Application by Highways England for an Order granting Development Consent for the A1 Birtley to Coal House Improvement Scheme

The Examining Authority's schedule of changes to the draft Development Consent Order (dDCO)

Issued on 16 June 2020

**ALLERDENE BRIDGE (3 SPAN OPTION)
SECTION A-A**
SCALE 1:100

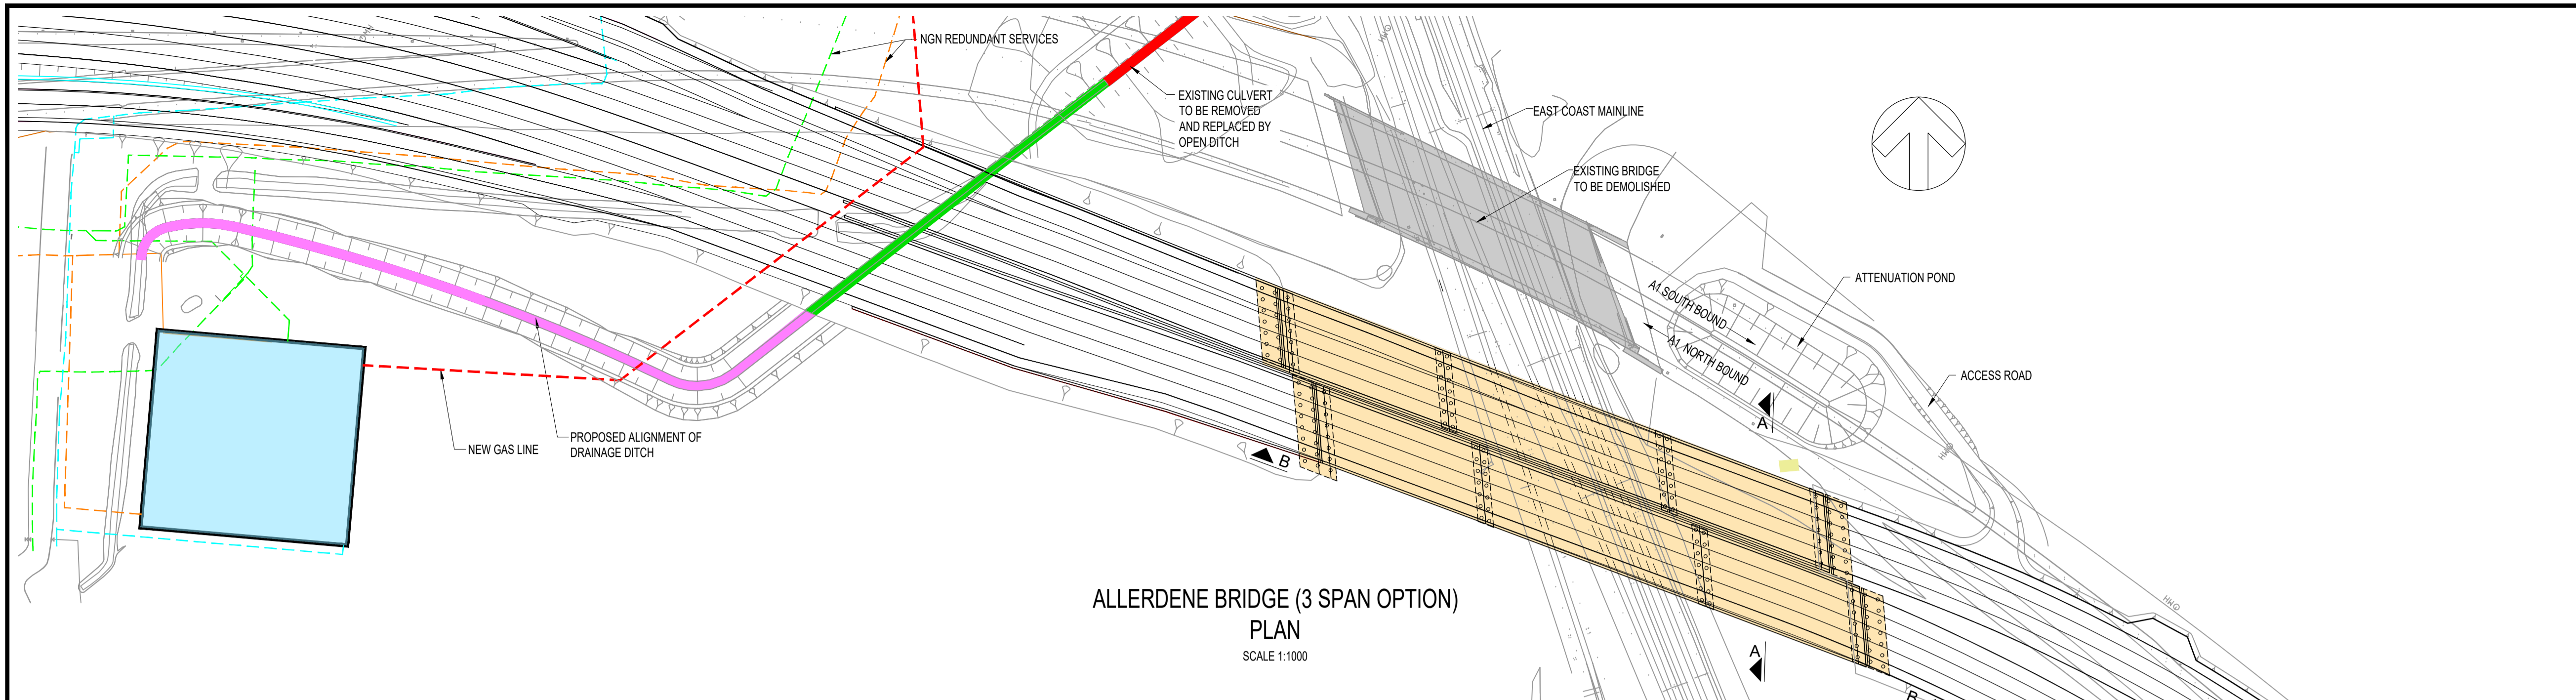
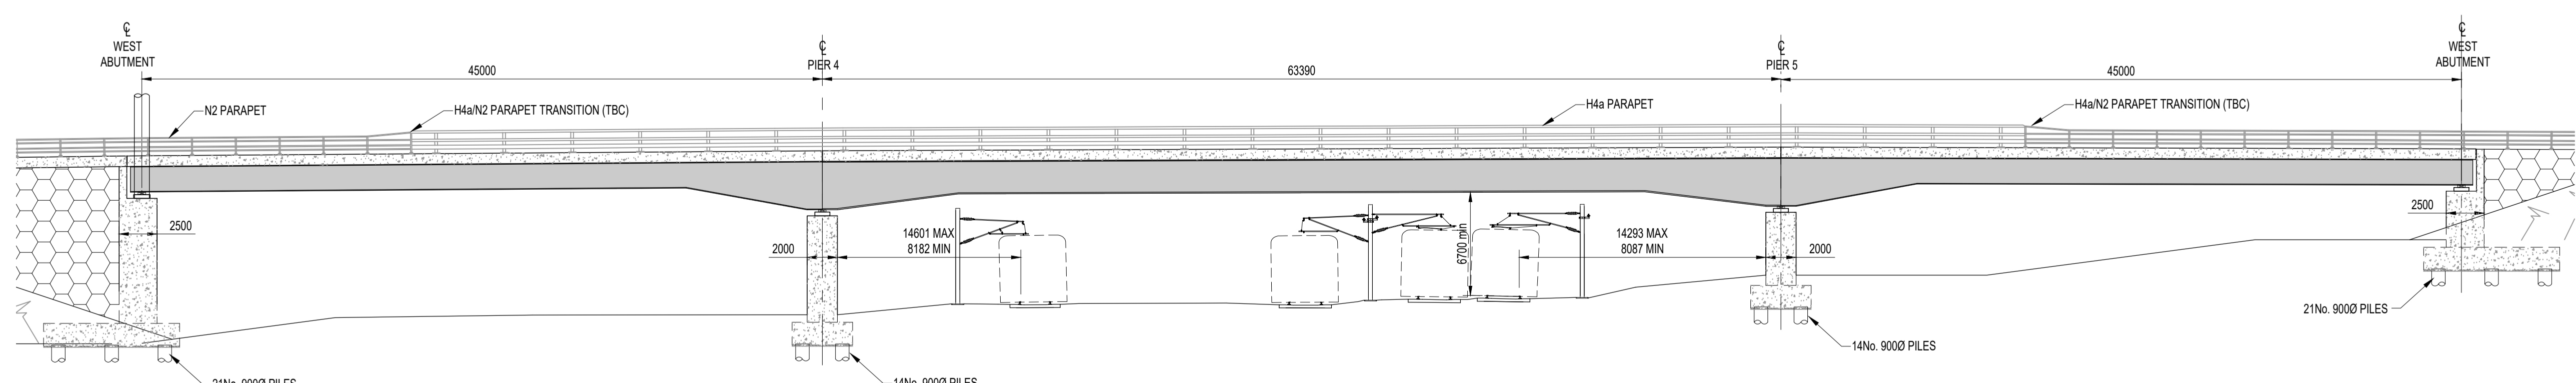
Ref	ExA's suggested changes	ExA's comments
R14	<p>14. Allerdene bridge replacement</p> <p>The undertaker is restricted to carrying out Work No.5a as either one of the works specified in paragraph (i) or (ii) of Work No. 5a as follows:-</p> <p>(a) In the event that the Work No. 5a is to comprise a single span bridge structure in terms of paragraph (i) of Work No. 5a then it shall be carried out generally in accordance with Sheet 3 of the structures engineering drawings and sections;</p> <p>(b) In the event that the Work No. 5a is to comprise a six span bridge structure in terms of paragraph (ii) of Work No. 5a then it shall be carried out generally in accordance with Sheet 4 of the structures engineering drawings and sections;</p> <p>(c) In the event that the Work No. 5a is to comprise a seven span bridge structure in terms of paragraph (ii) of Work No. 5a then it shall be carried out generally in accordance with Sheet 5 of the structures engineering drawings and sections;</p> <p>(d) In the event that the Work No. 5a is to comprise a three span bridge structure in terms of paragraph (ii) of Work No. 5a then it shall be carried out generally in accordance with Sheet 16 of the structures engineering drawings and sections.</p>	<p>The use of the word 'generally' is unprecise and may result in design revisions that do not accord with paragraph 4.29 of the National Networks National Policy Statement seeking the demonstration of good aesthetics as far as possible.</p> <p>The ExA also questions whether further drafting is required to secure some of the design measures referred to in the Applicant's response to ExQ2.0.4 [REP4-052] (e.g. bespoke parapet details).</p>
